Application for Planning Permission for Works or Extension to a Dwelling

Development: Single storey rear extension with skylight
garage conversion
Location: 5 Downlands Close Pagham PO21 3QA

I regret that I am unable to accept your documents as a valid application until the following item(s) have been received or resolved :-

Mr. & Mrs. Leadston
5 Downlands Close, Pagham
West Sussex PO21 3QA
PROPOSED FLOORPLANS
A3 PAPER
Date: Aug. 2025 Scale 1:100 Dwg.no. PR.FP. 01

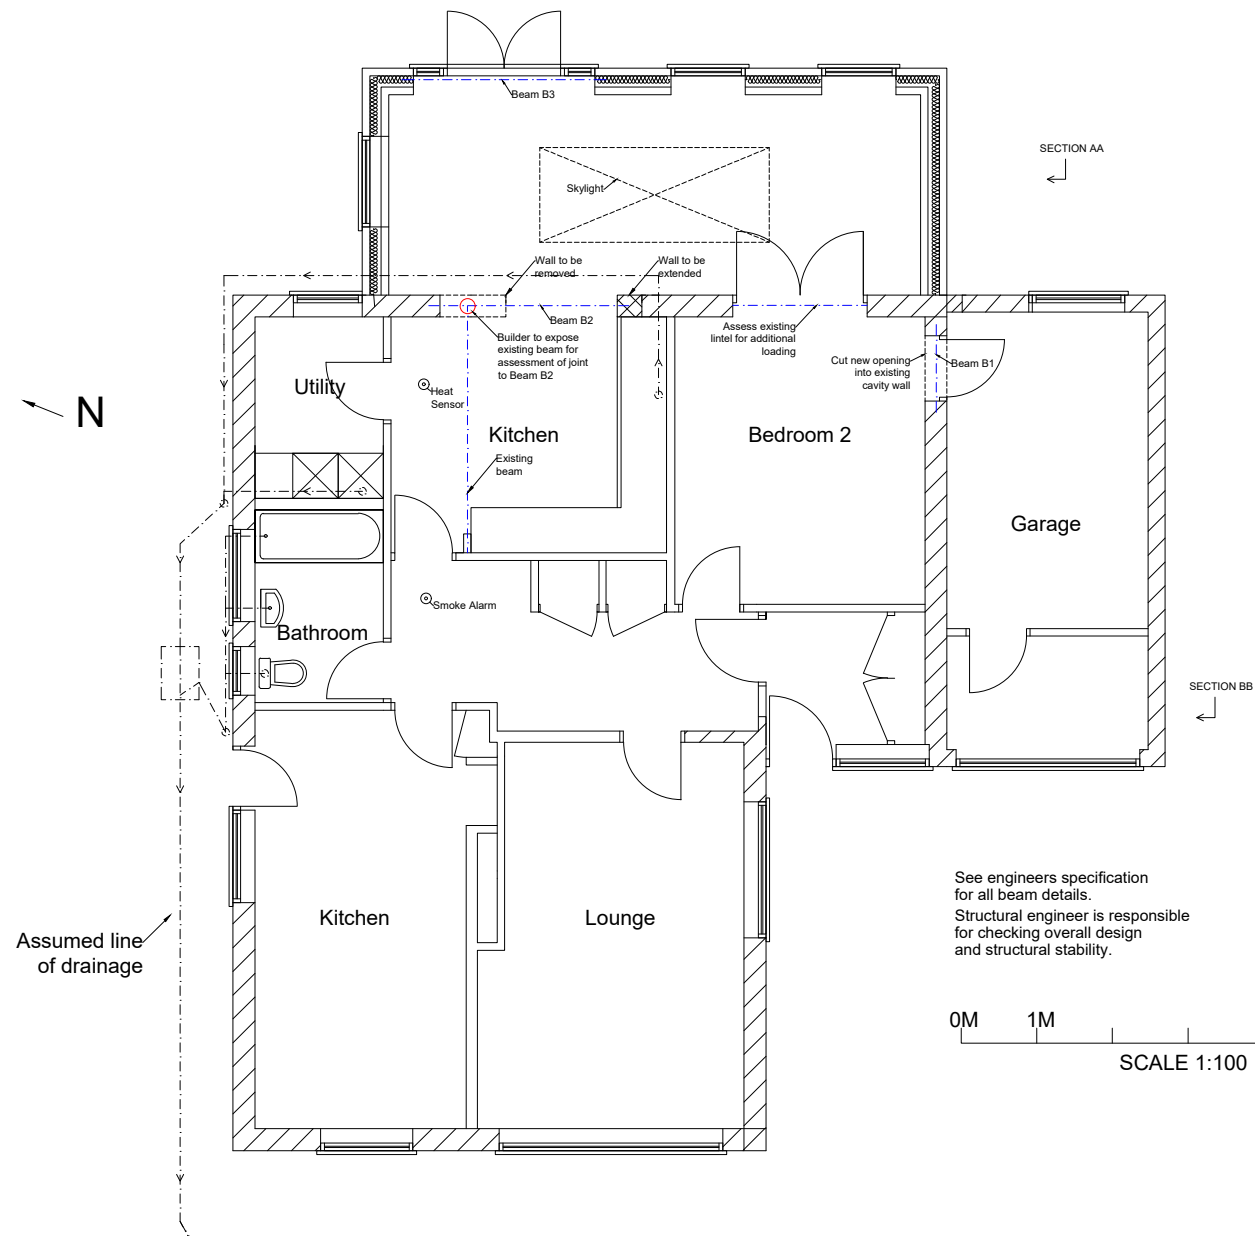
Proposed Floor Plan

The proposed floor plan does not measure to scale, please review and amend.
